Your ref: SSD 7198
Our Ref: 0820732

**SSD 7198 – Moonee Beach Residential Subdivision
Interim Response to RFI issued 15 July 2019**

Attachment A
Revised Subdivision Plans – Civiltech

ROAD 7 - LONG SECTION

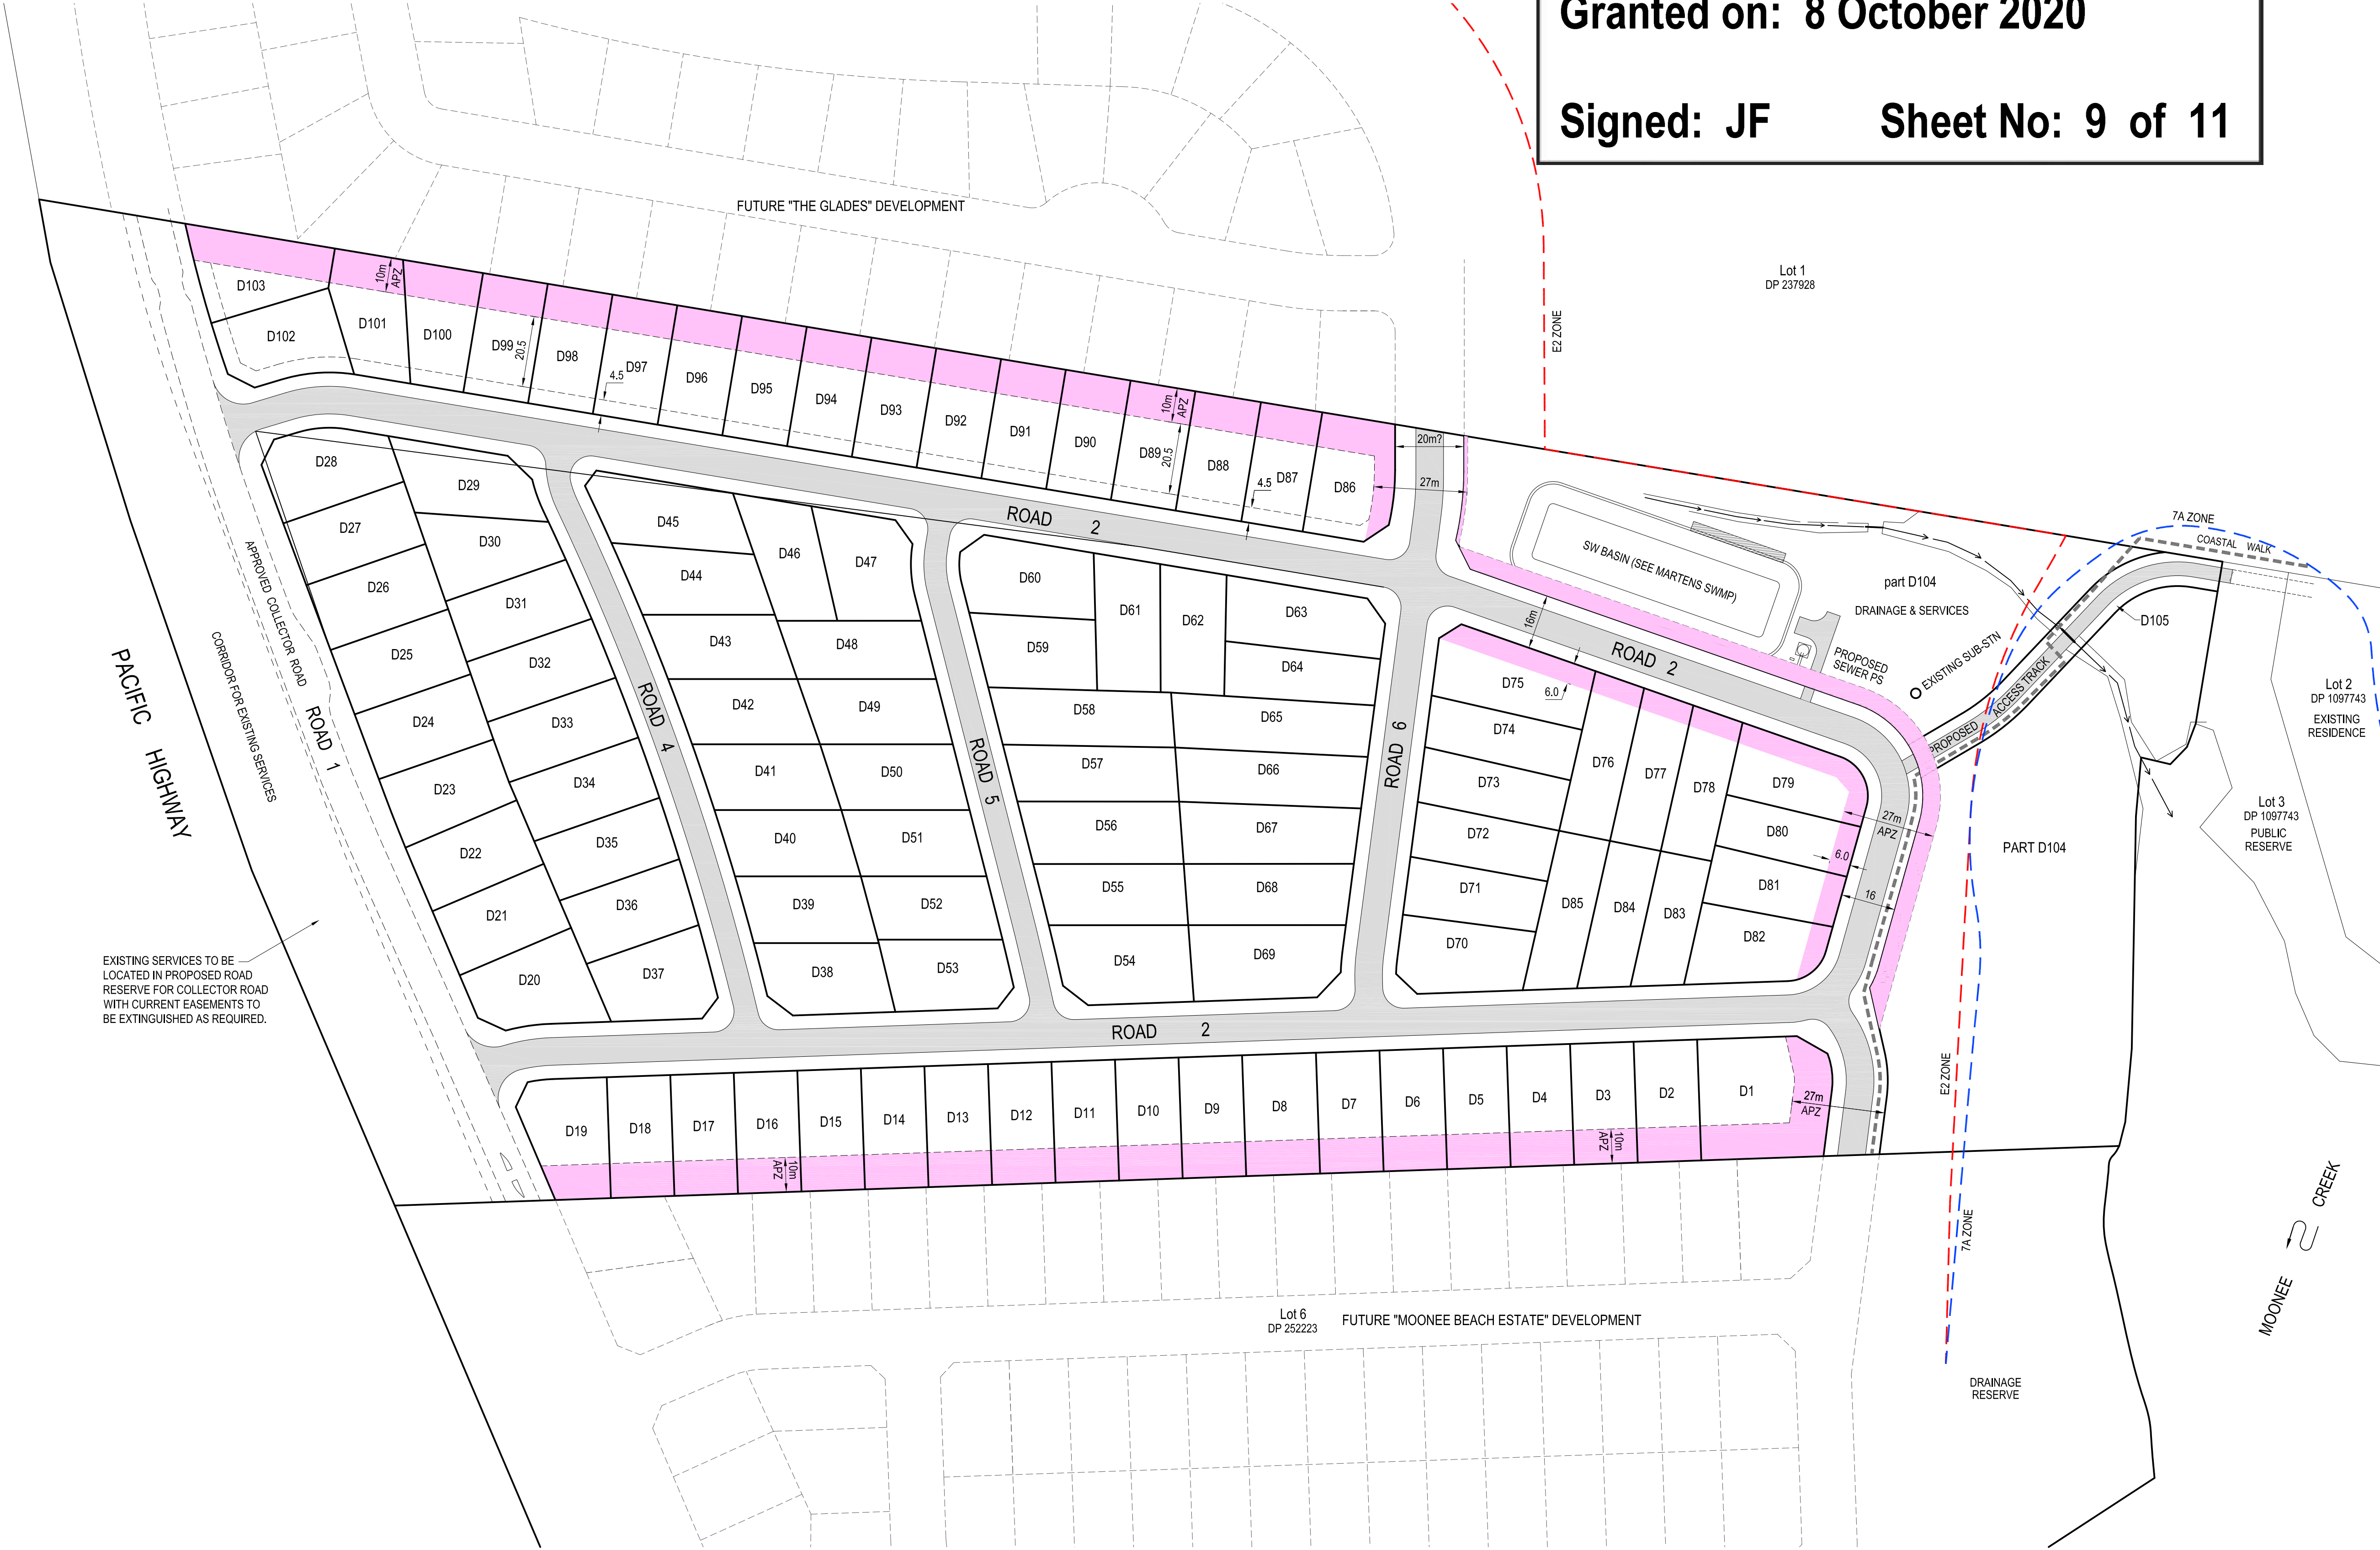
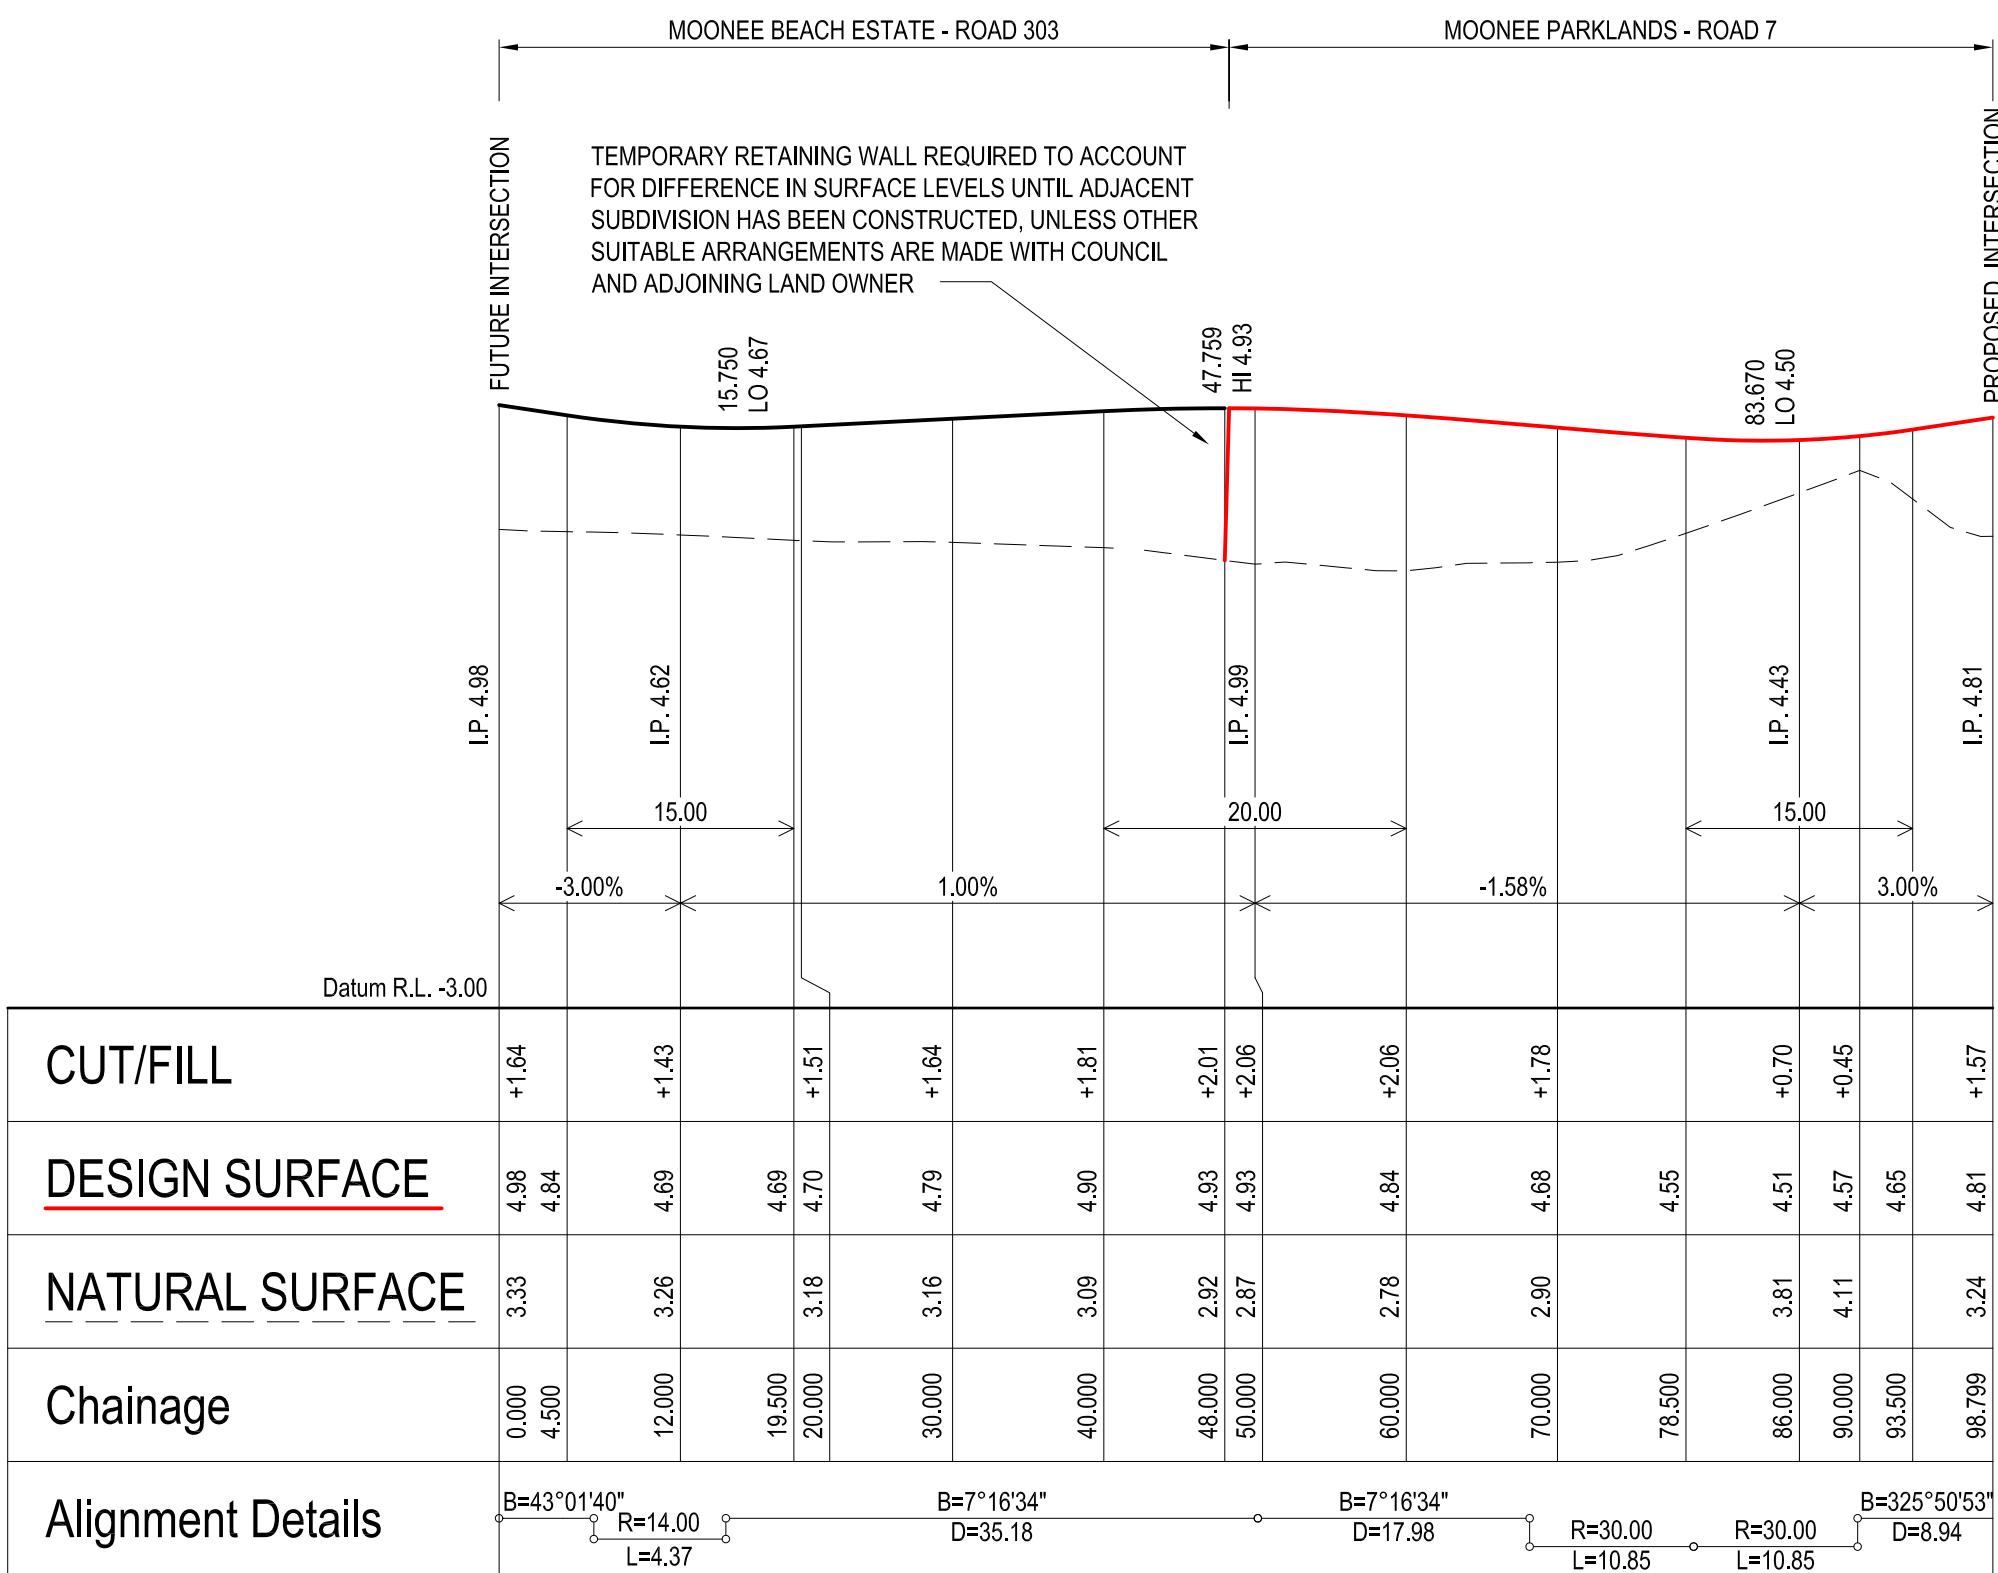
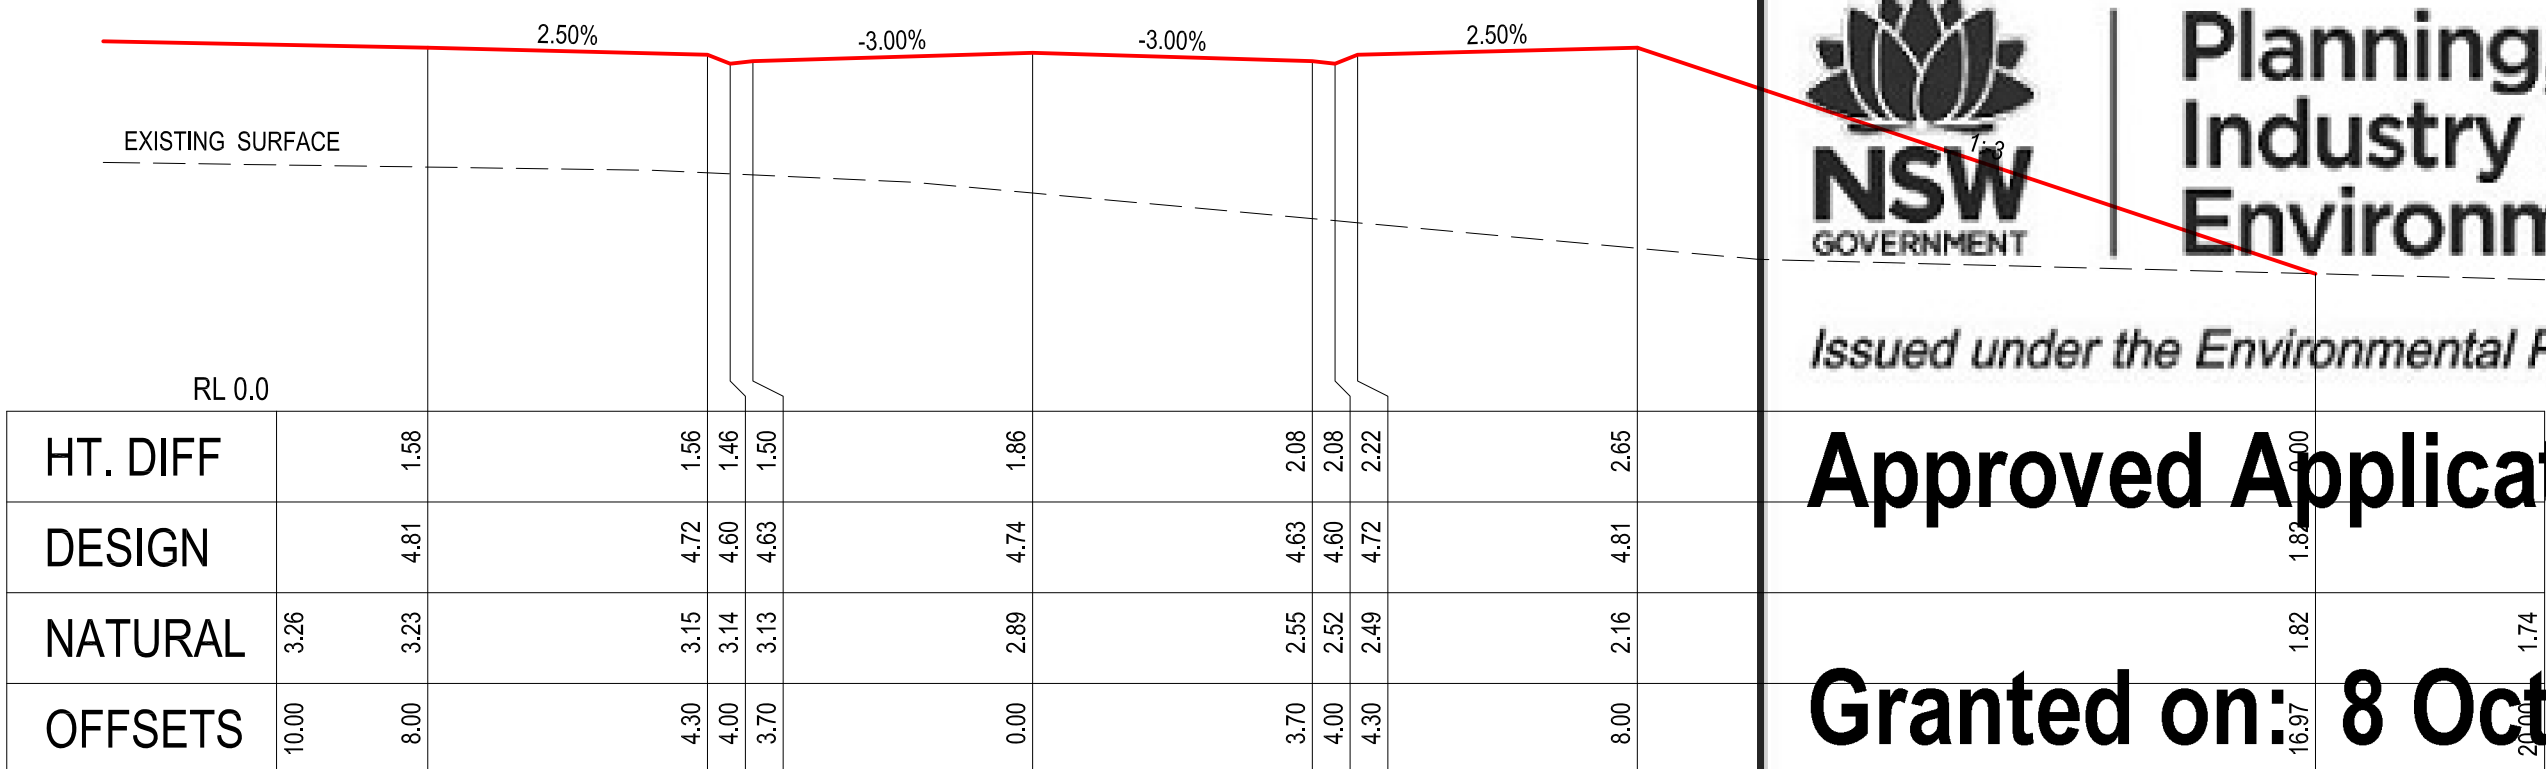
Further evidence is required demonstrating that the road reserves are capable of complying with Council's requirements, including infrastructure and street trees being accommodated.

The CHCC Development Design – Geometric road layout sets road geometry requirements for a range of road types. Roads 2, 6 & 7 are classified as Local streets with vehicle movements up to 2,000 vpd. They are required to be 8m wide with minimum 4m verges. Roads 4 & 5 are classified as access streets and require to have a width of 5.5-7.0m. The proposed roads 4 & 5 are 6.5m wide in a 14m verge. Additional details of service allocations have been added to the plans.
